RE: Comments and questions on SUB19-002

East Seattle School proposed parcel subdivision

PRELIMINARY UTILITY PLAN
2825 W MERCER WAY
 PRELIMINARY PLAT
 PARCEL #2174502425
 CITY OF MERCER ISLAND WASHINGTON

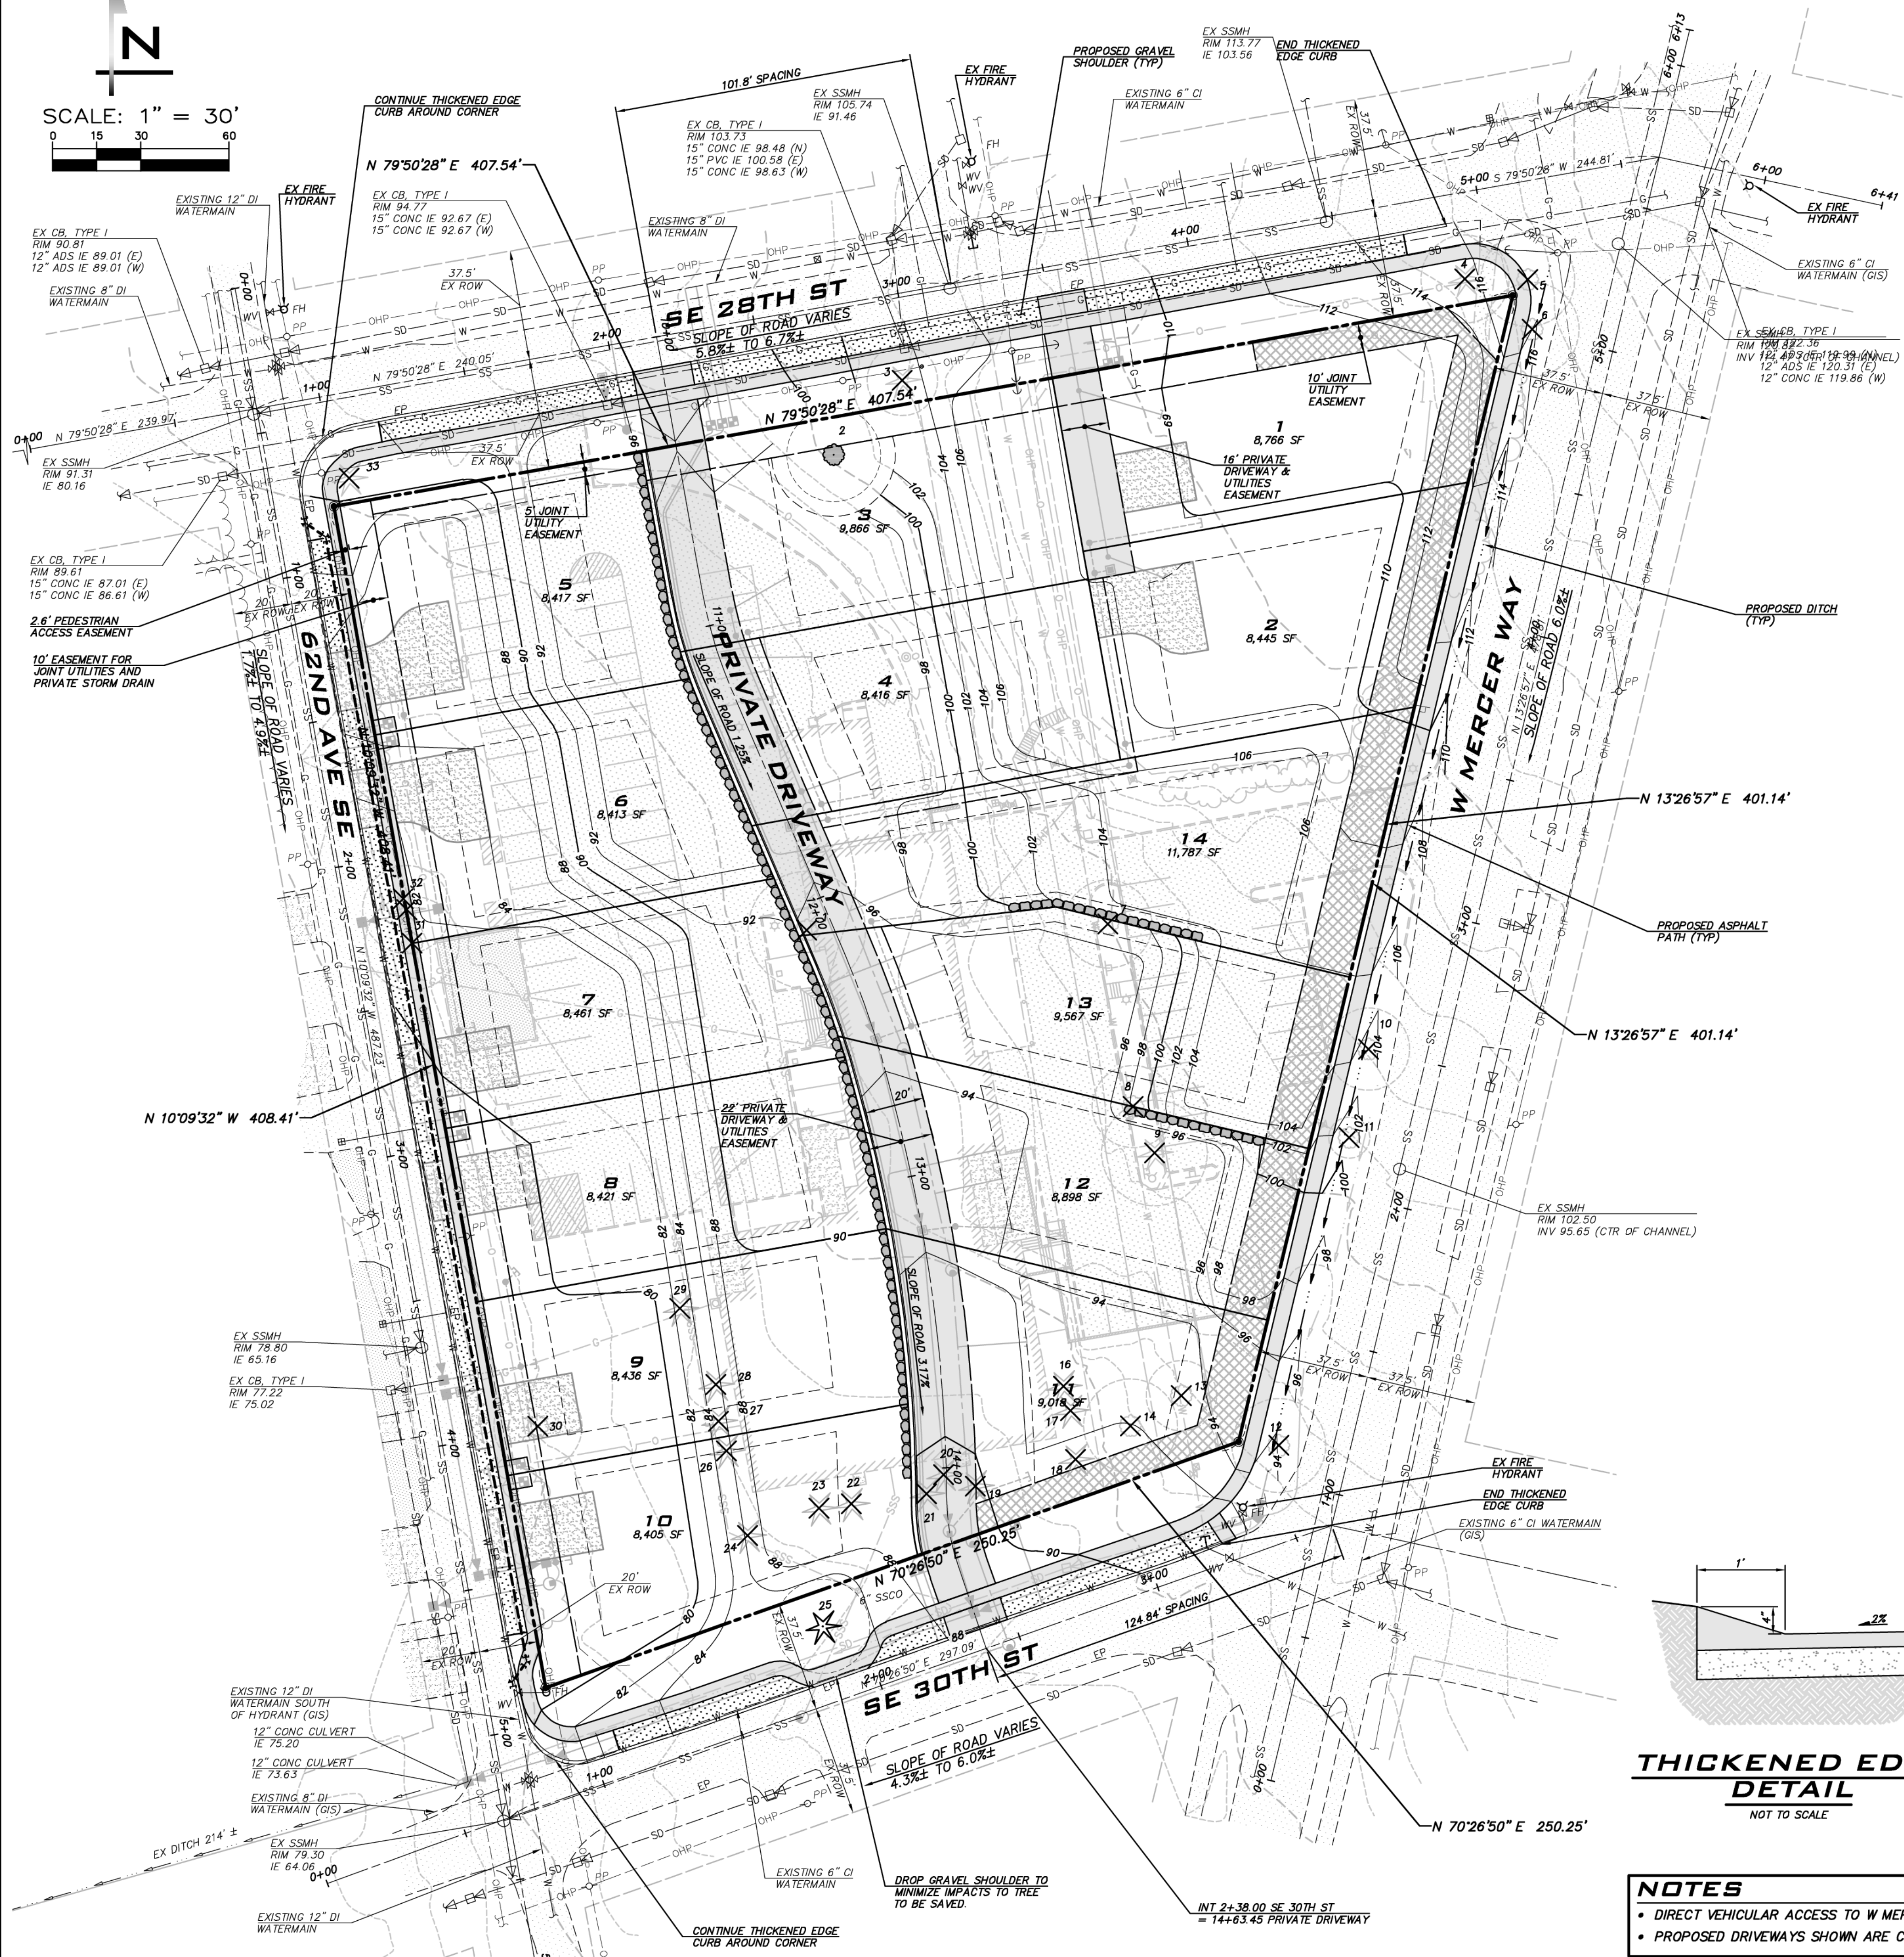
- 8) What about storm water run off, drainage, sedimentation especially with proposed tree removal? This does not appear to be properly addressed and must be. The water and run off cannot get dumped directly into the lake. This is apparently not per code and should be re-reviewed and correctly addressed

PRELIMINARY ROAD PLAN & SECTIONS
2825 W MERCER WAY
PRELIMINARY PLAN
PARCEL #2174502425
CITY OF MERCER ISLAND WASHINGTON

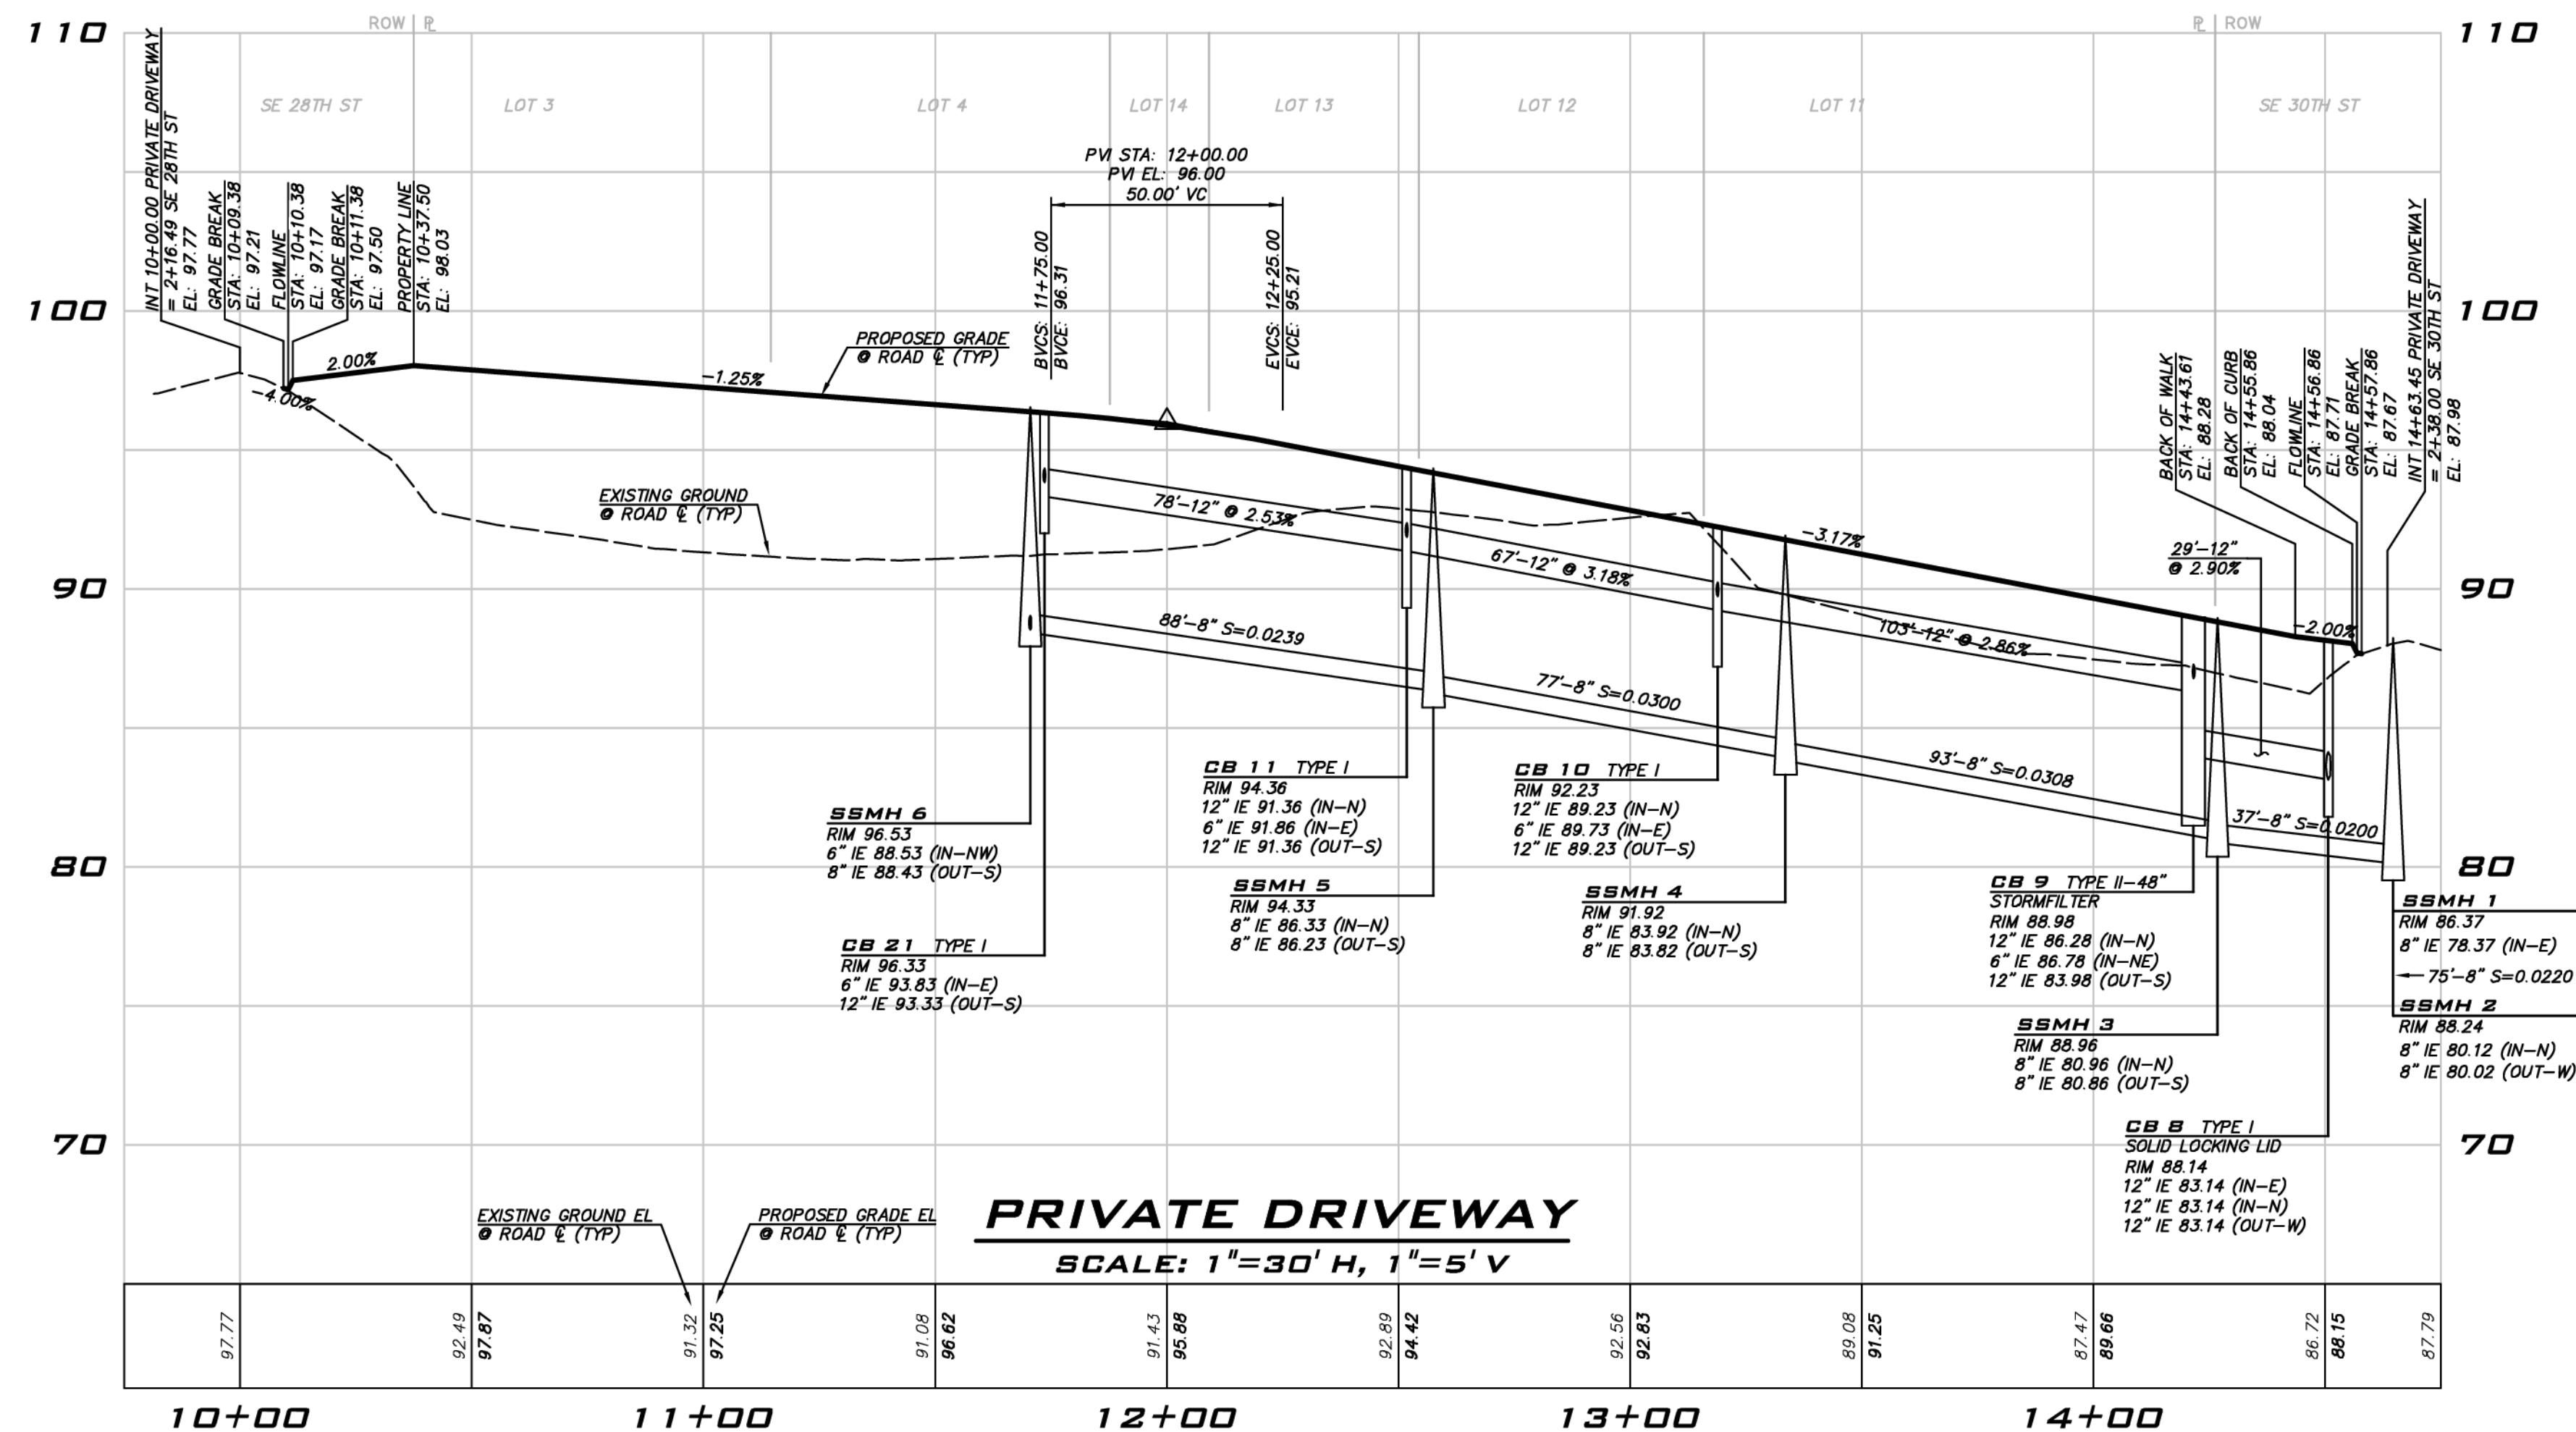
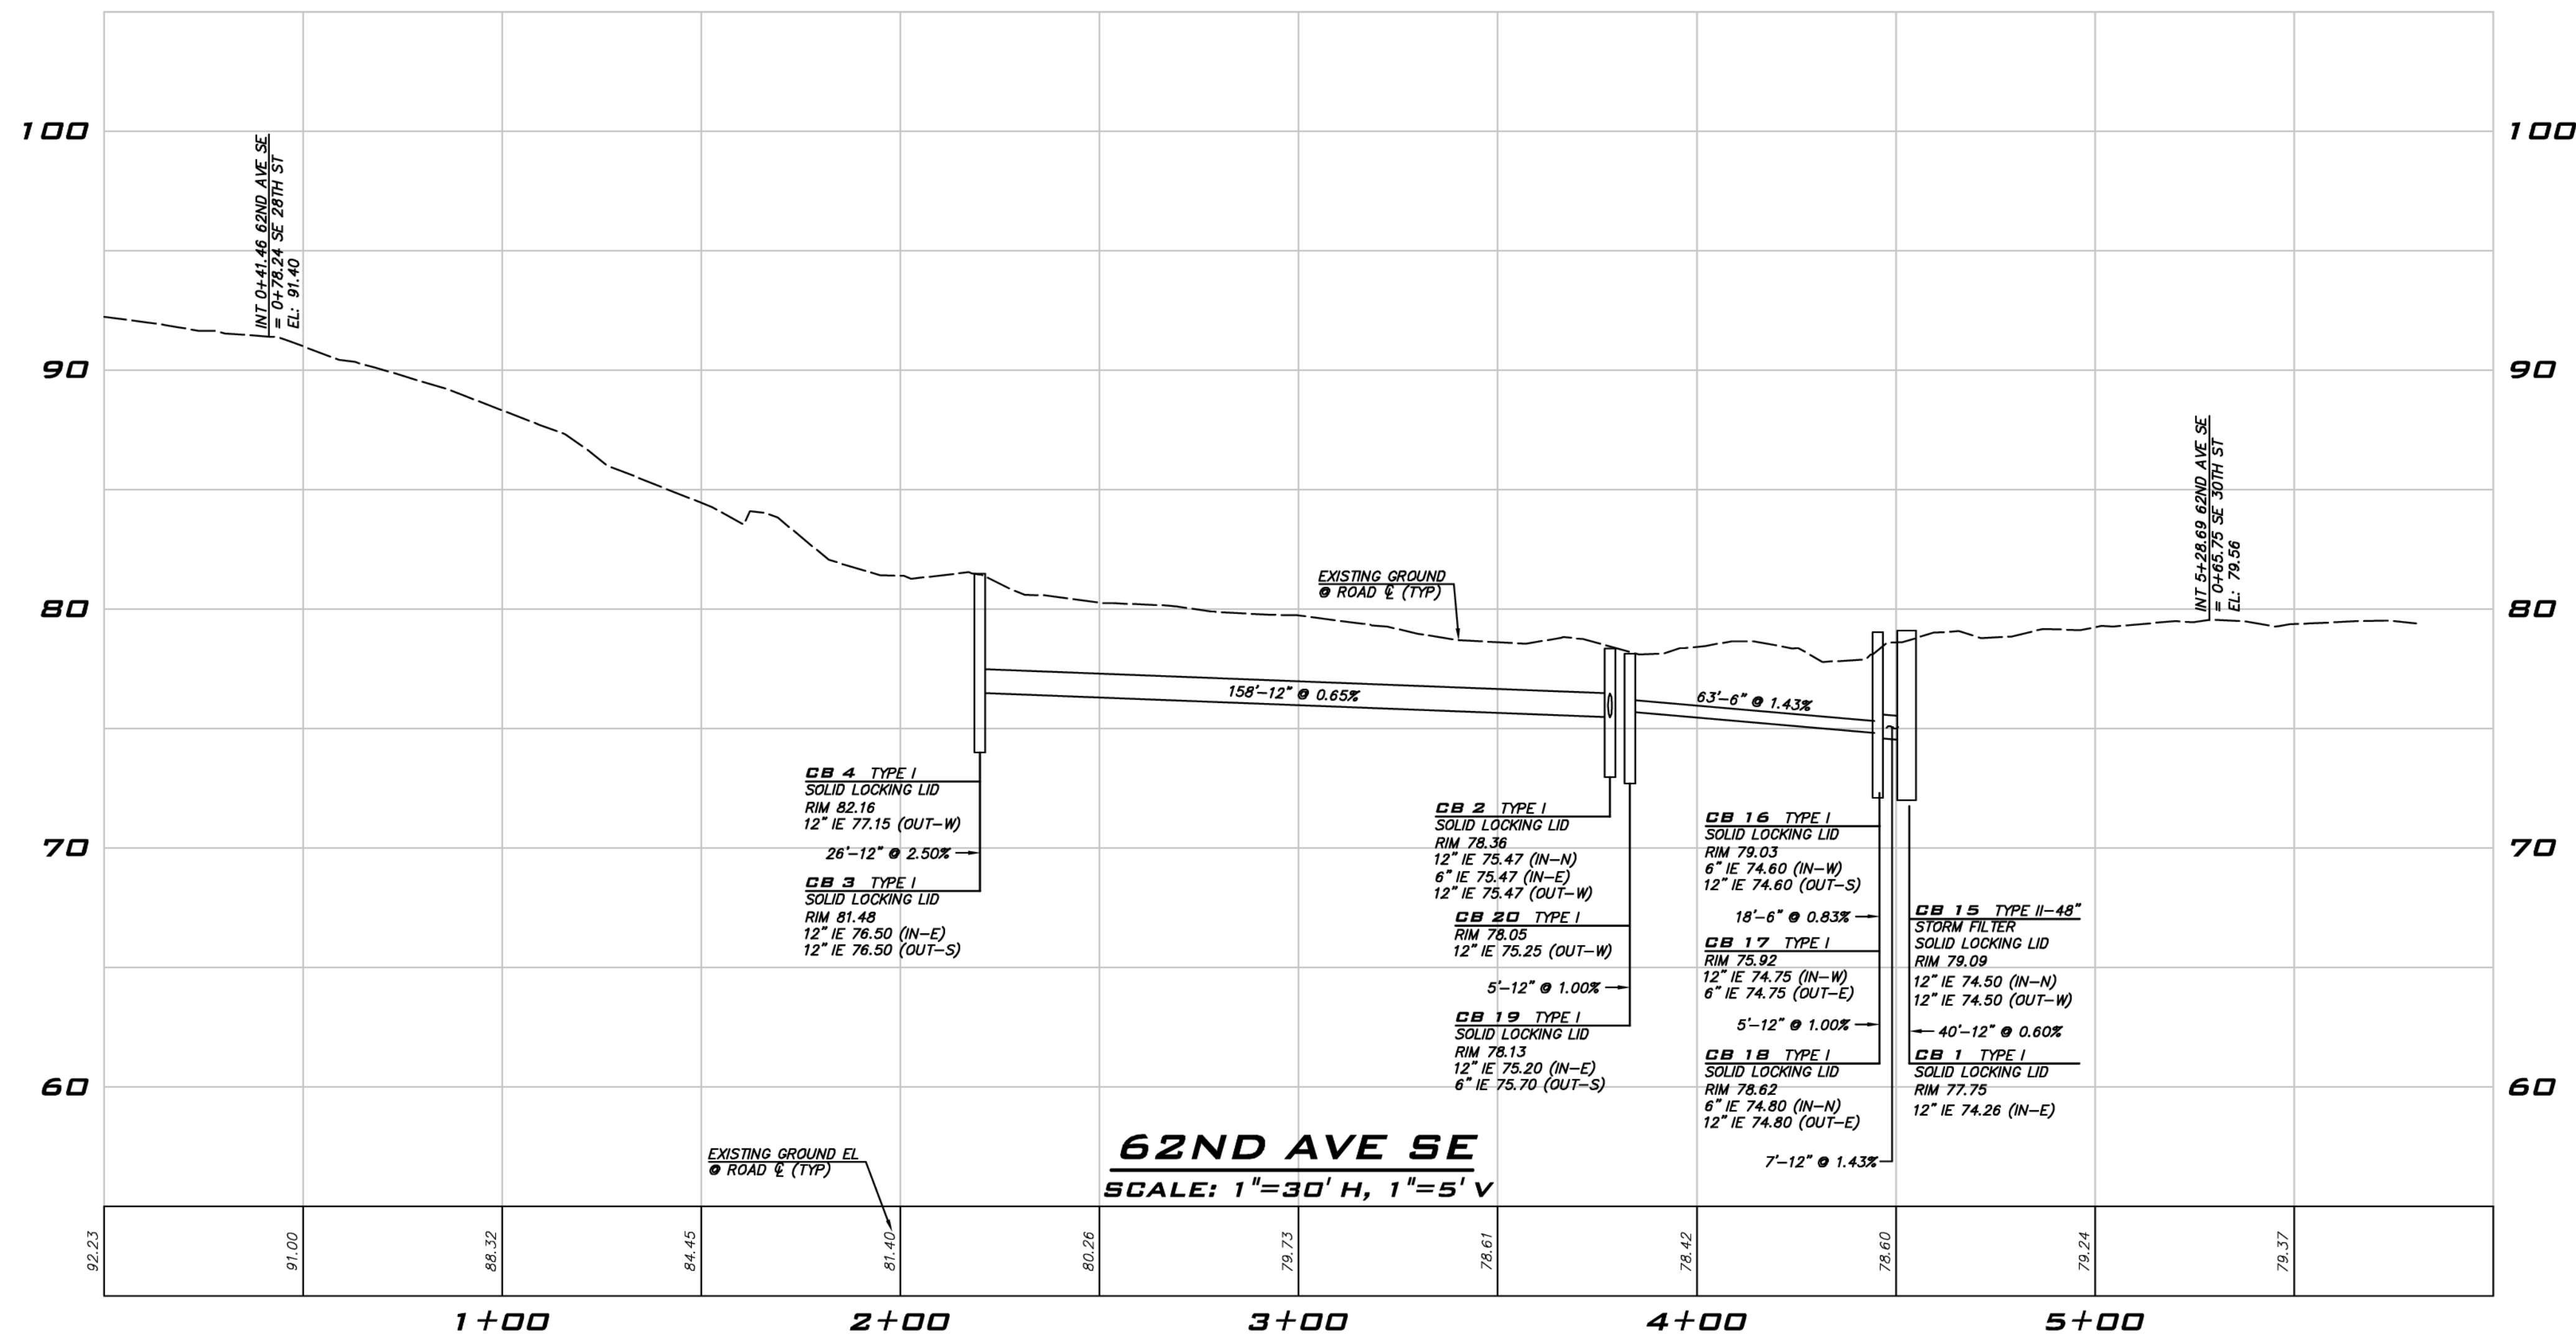
- 4) Driveways – please explain why, with the small footprint of 62nd Ave., would the developer ask to “dump” vehicles from six homes onto this street, rather than access ALL the proposed homes from the interior private drive? This makes no sense.

- 5) Sidewalks: Normally this would be required in a long plat, i.e. the developer must install sidewalks. Why is this ignored?
- 6) Structure height: The maximum per code is 30', this is to be from the LOWER point i.e. existing grade or altered height of grade. This should include any appurtenances, such as flagpoles or other items. Height of 30' is to the highest point of the roof.
